EPC STORMWATER REVIEW COMMENTS  
IN ORANGE BOXES WITH BLACK TEXT

# VOLLMER ROAD (NORTH)

## GRADING AND EROSION CONTROL PLANS

FEBRUARY 2023

VOLLMER ROAD  
STA 33+50 TO STA 43+00

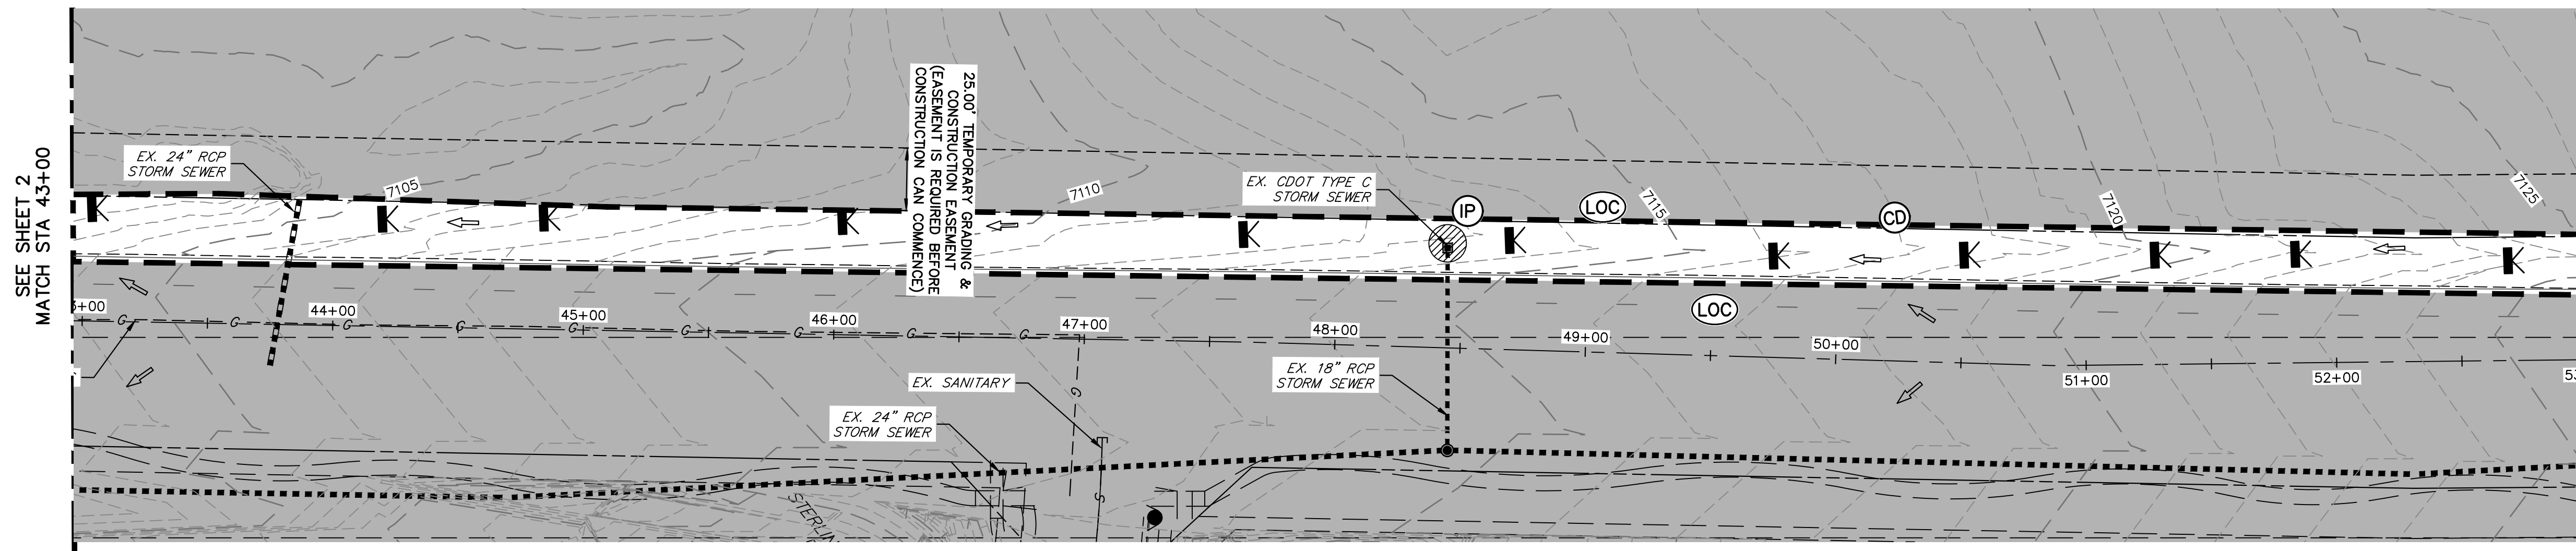
Provide inlet protection.

Provide VTC for this access point of the project.

CD's call out this shape as an existing SFB - label on all sheets.
